# **KIRKLEES METROPOLITAN COUNCIL INVESTMENT & REGENERATION SERVICE**

| Reference No:         | <b>2024/62/93544/W</b>                         |
| Site Address:         | 3D, Broad Lane, Upperthong, Holmfirth, HD9 3JS |
| Description:          | Erection of 2 garden pods                      |

scale	date	sheet size	dwg. no.
1:500	12/2024	A3	24/1112/06a

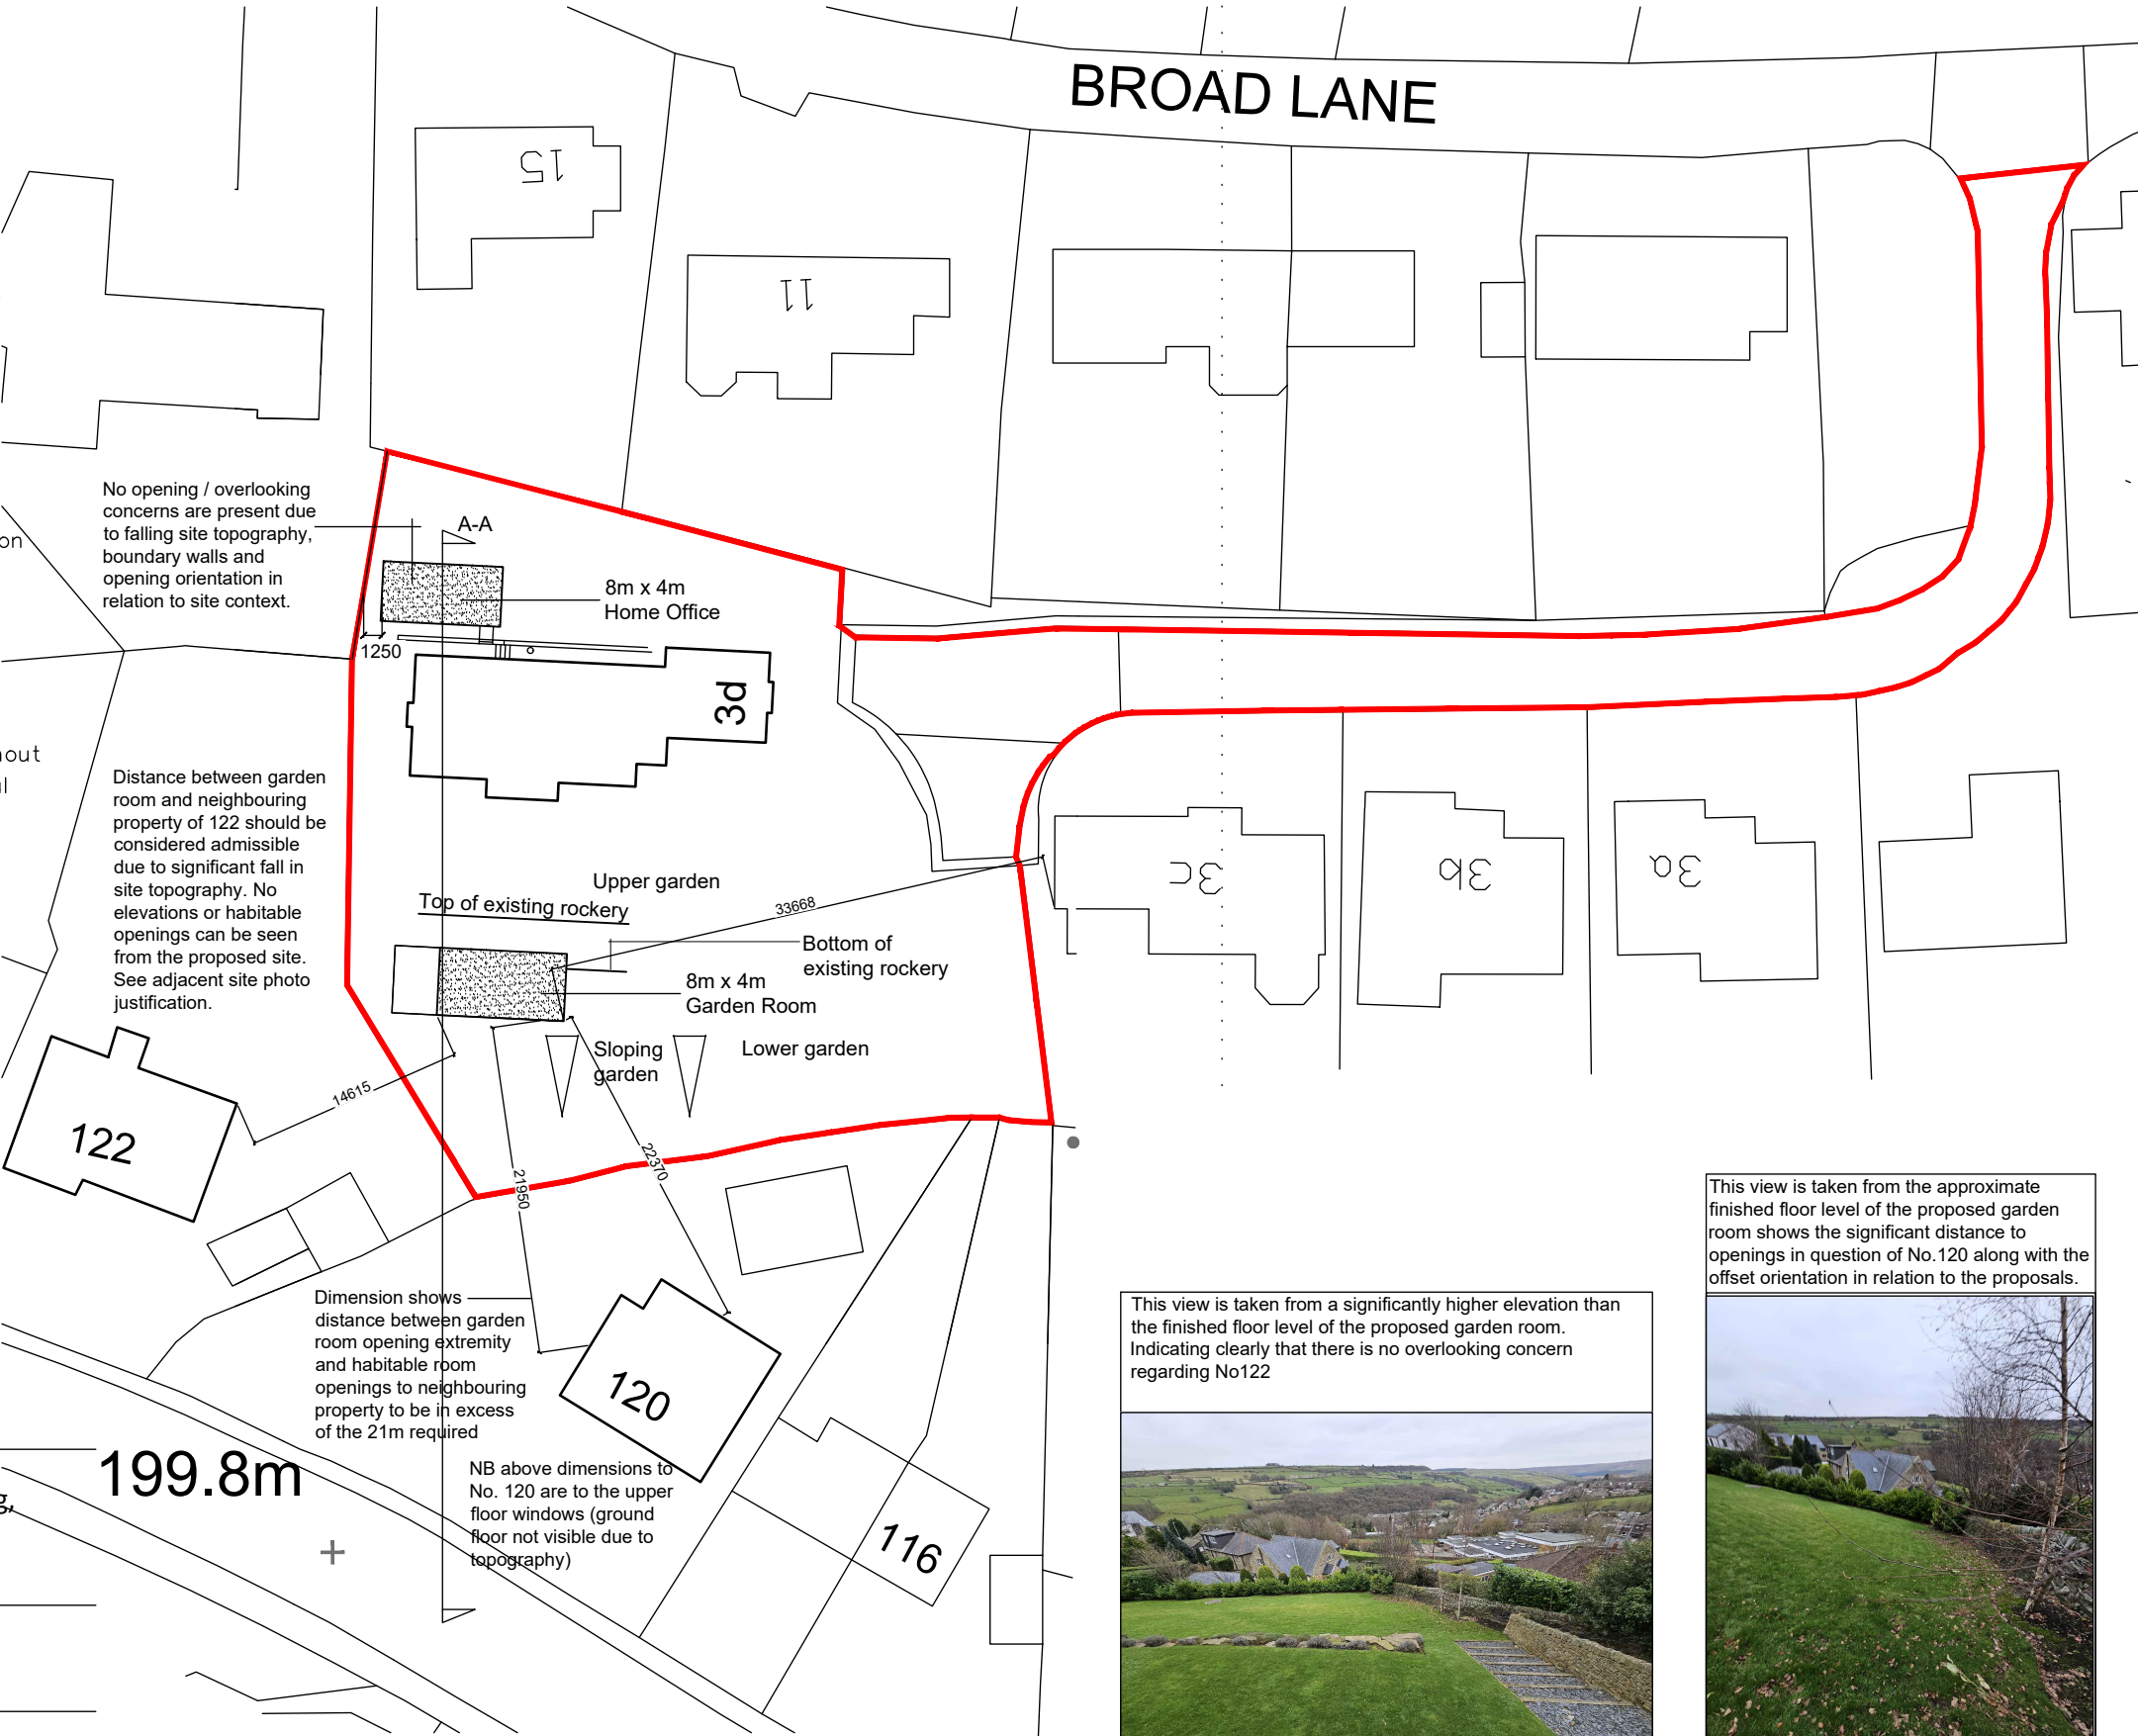
The agent was contacted regarding the distances between the proposed outbuildings and neighbouring properties. The agent responded with plans which showed the proposed outbuildings with relation to existing neighbours and these distances clearly measured.

The second outbuilding, located to the south of the property will have an extensive amount of glazing within the south and west elevations. The agent provided further detail on the separation distances to surrounding properties. They stated that the nearest neighbouring properties to this outbuilding would be located at a distance of 14.6m and 18.5m away. Further to this by considering the topography of the site in relation to surrounding development although the outbuilding would be on a higher ground level this change in ground level means that none of the ground floor of neighbouring property 120 Greenfield Road can be easily viewed from the subject property lower garden area (where the garden room would be located).

Furthermore the orientation of the nearest two properties and the proposed building is such that there is not a direct relationship between the buildings and they would be at an oblique angle to one another. As such it is concluded that given the separation distances, siting in relation to one another and topography of the site the proposed outbuilding to the south would not cause a significant level of over shadowing be unduly overbearing or lead to an unacceptable level of overlooking / loss of privacy.
